CITY OF ALBUQUERQUE

June 6, 2022

Re: Duplexs for Ahmet Tirkaki
12100 Copper Ave NE
Traffic Circulation Layout
Architect's Stamp 05-22-2022

1 TRAFFIC CIRCULATION LAYOUT

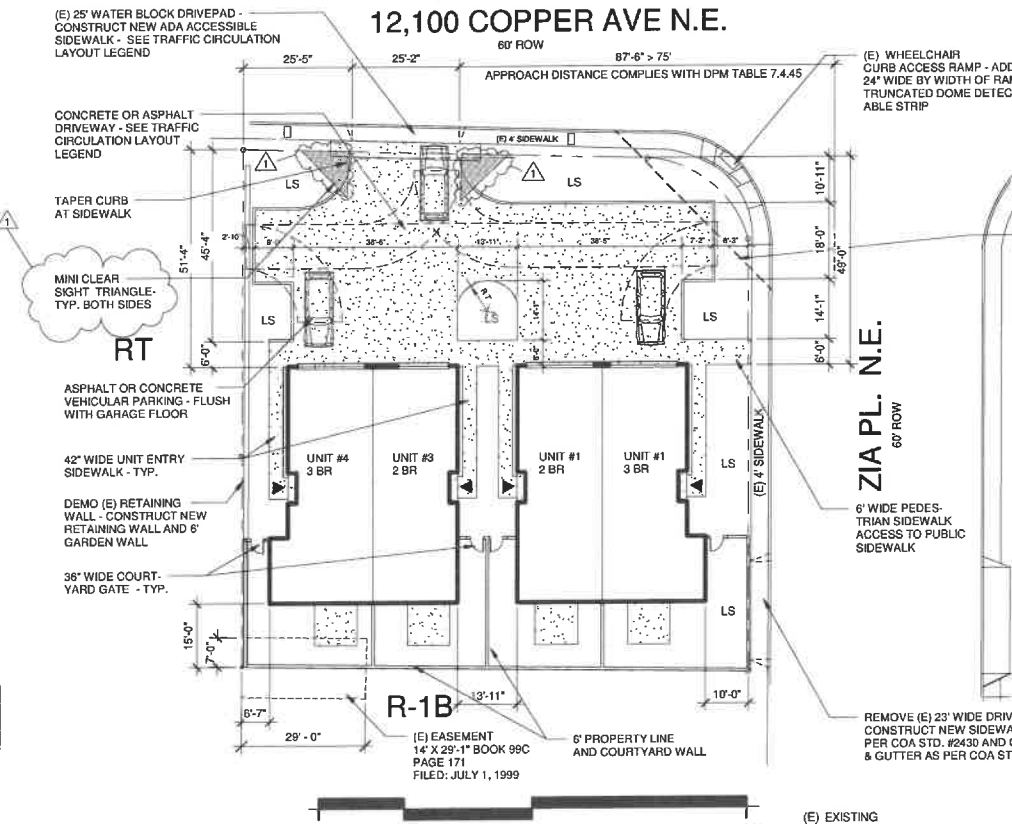
1. Pavement Section: 6" of concrete is the minimum for a driving surface. Please call this out on you Site Plan.
2. Sidewalk concrete is 4".
